From: Scott Castle [REDACTED]
Sent: 02 October 2019 10:00
To: Carol Reynolds <Carol.Reynolds@arun.gov.uk>
Cc: Anita Gardner <Anita.Gardner@arun.gov.uk>; [REDACTED]
Subject: RE: 22 Beach Road, Littlehampton.
Importance: High

Thank you for your report, Issue 1, dated 20th September 2019 in respect of Project Number J2707, (as attached), which was amended in the light of my previous comments and my E Mail 4th September 2019, as below.

Figure 4. Internal Measurement Positions

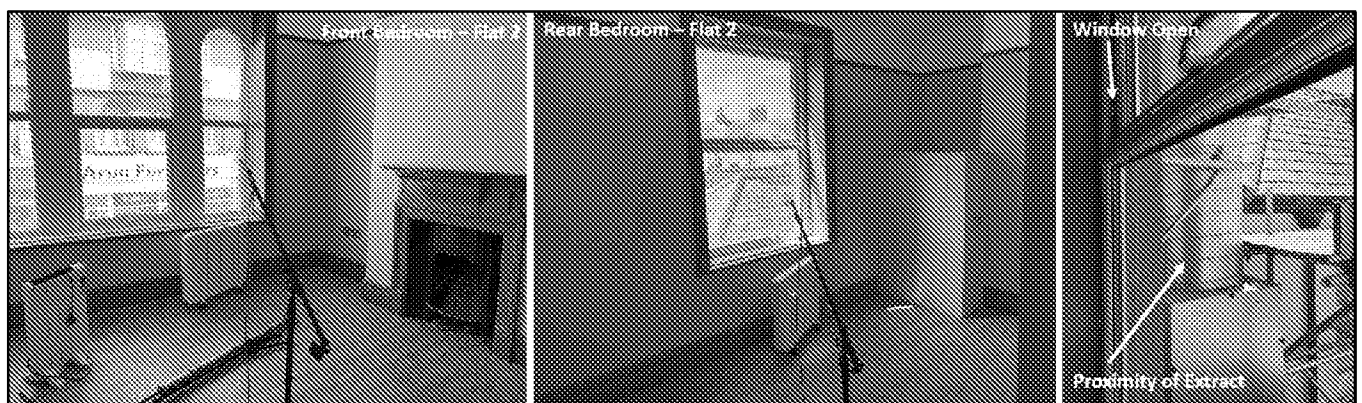
The reverberation times were measured in each of the locations where the surveys were undertaken. As noted from Table 3 in the report, the front bedroom in flat 2, was considerably higher in terms of reverberation than the smaller two bedrooms measured. As per Figure 4 of the report, the image displayed on the left hand side shows the laminated floor already laid.

Figure 7. Review of 1-hour periods inside Flat 1 bedroom

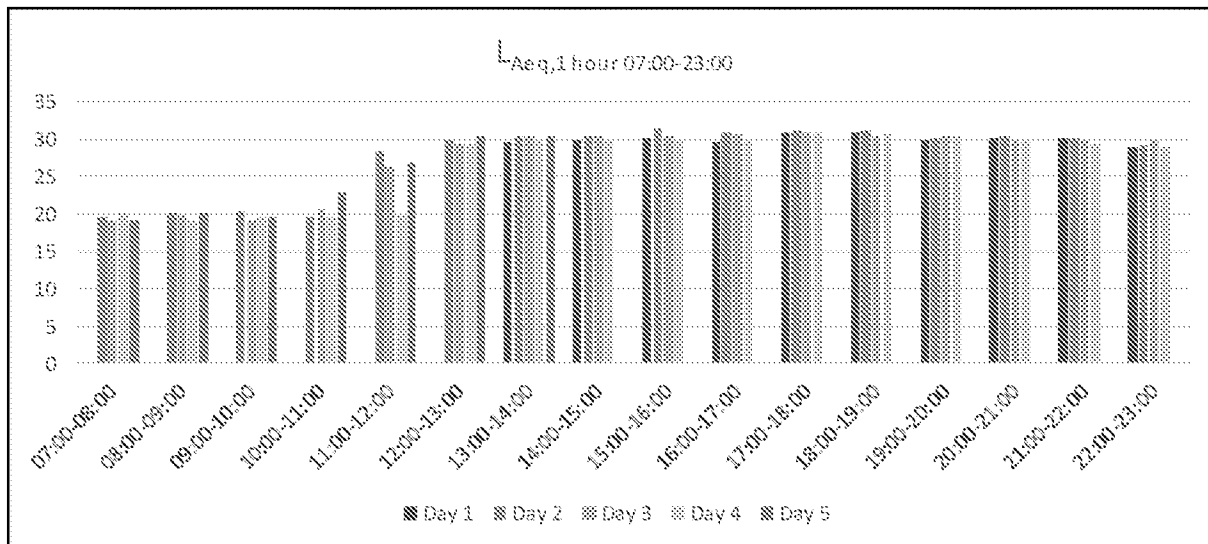
In respect of your report, 23rd August, page 3, paragraph 3 then to clarify, my comment related to Figs 6 & 7 and Flat 1 where daytime noise was found to be 28.8 with windows closed and therefore 39 to 44dB with reasonable adjustment for an open window.

Figures 6 and 7 in the report relate to Flat 1, however the references to 39 and 44dB relate to Flat 2, front bedroom, which is reported in Figure 10.

Figure 4. Location of Condensers serving Walk in Chiller

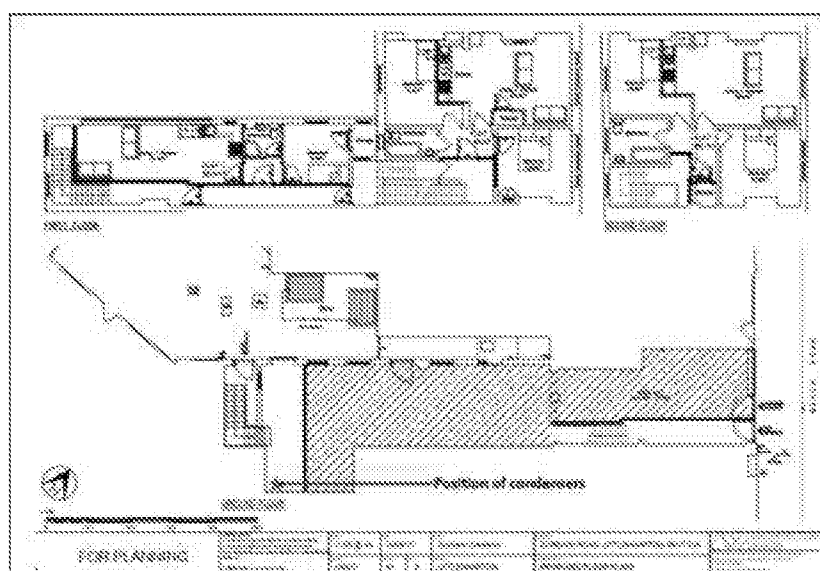
1. The condenser unit for the Walk in chiller.

The condensers were previously located below the bedroom window but have since been relocated to inside the rear garage unit at the very rear of Flat 1, outside the demise of the flat.

The condensers are mounted on anti-vibration mounts on the ground floor. Both the garage and the pizza hut ceiling were soundproofed at the same time. The condenser positions inside the garage void are shown below.
